**DELEGATED DECISION TO DETERMINE APPLICATIONS FOR
CONSENT, AGREEMENT OR APPROVAL REQUIRED BY CONDITION**

Reference No:	2024/44/91542/E
Site Address:	Centurion House, Centurion Way, Cleckheaton, BD19 3QB
Description:	Discharge of condition 16 (parking) of previous permission 2022/92271 for demolition of Centurion House, erection of petrol filling station and ancillary unit with drive-thru and associated works
Recommending Officer:	Louise Bearcroft

DECISION – Discharge of Condition – Approve

Client	EURO GARAGES
Project	CLECKHEATON SERVICES
Title	SECTION 278 LINING WORKS
Drawing No.	WL_2390_002
Revision	P2
Scale	AS INDICATED
Date	03.11.23
Drawn	S.A.S.
Chk	E.Z.
App	G.E.
Unit 2.1, 20 Dale Street, Manchester, M1 1EZ	
Tel. 0161 236 8203

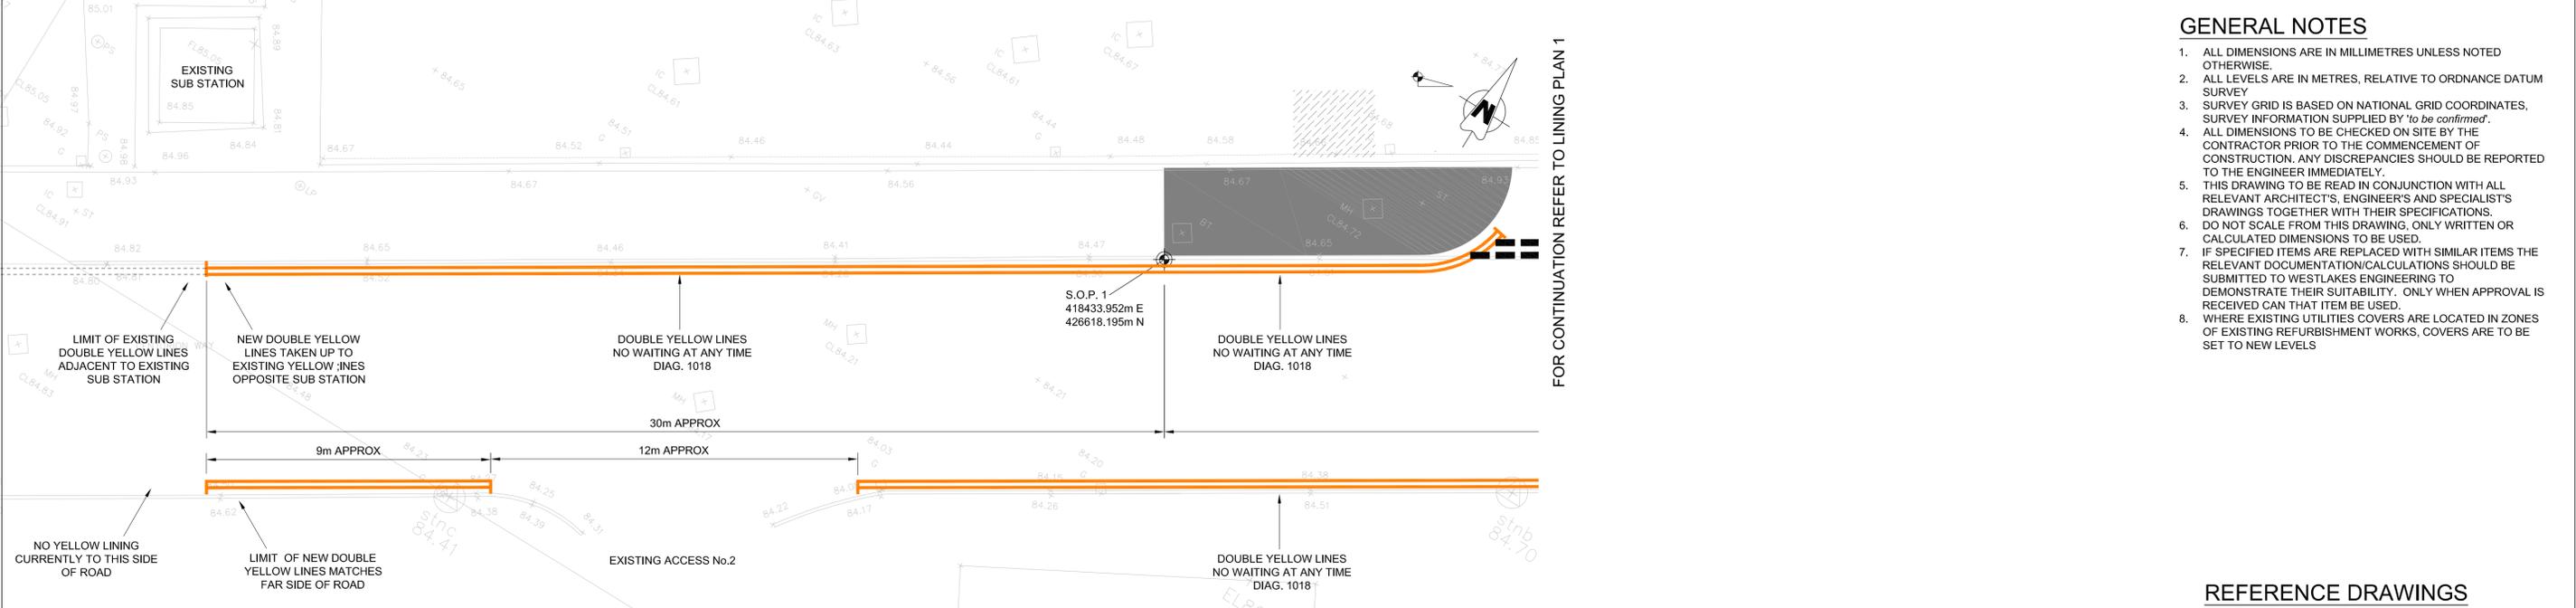
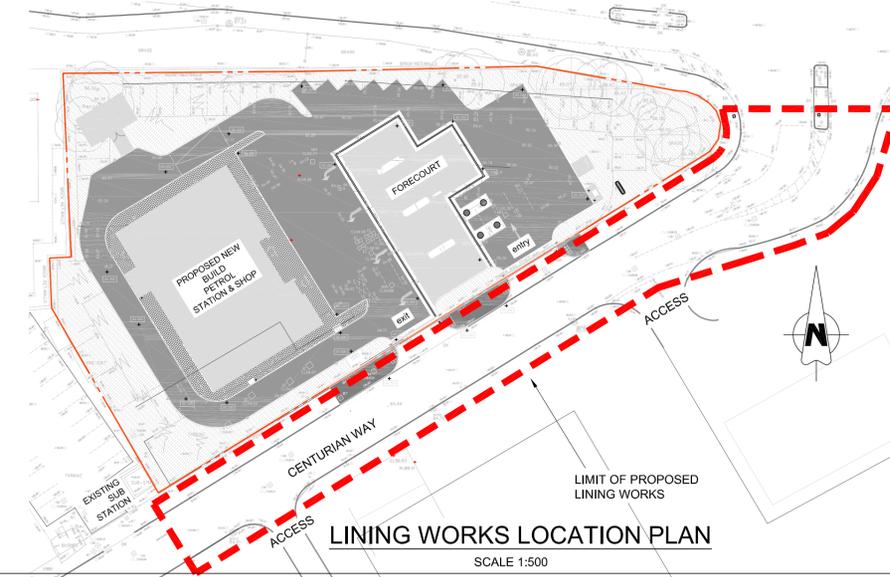
K.C Highways Development Management - The applicants have provided drawing WL-2390-002 P2 showing waiting restrictions on both sides of the road from the traffic lights to the extent of the proposed development. Highway Safety colleagues advise that the developer is in contact with the council's Highway Design section regarding implementation of the works and that the TRO has been advertised. The first part of this condition can therefore be discharged.

The applicants have provided drawing WL-2390-002 P2, which shows waiting restrictions on both sides of the road from the traffic lights to the extent of the proposed development. KC Highway Safety have advised that the developer is in contact with the KC Highway Design section regarding implementation of the works and that the TRO has been advertised. KC HDM therefore recommend that the first part of the condition can be discharged.

You have submitted the above documents and plans. The details therein are considered to be acceptable for the purpose of condition 16 and are hereby approved. The condition cannot be fully discharged at this stage as it requires that no part of the development shall be brought into use until the approved scheme has been implemented.
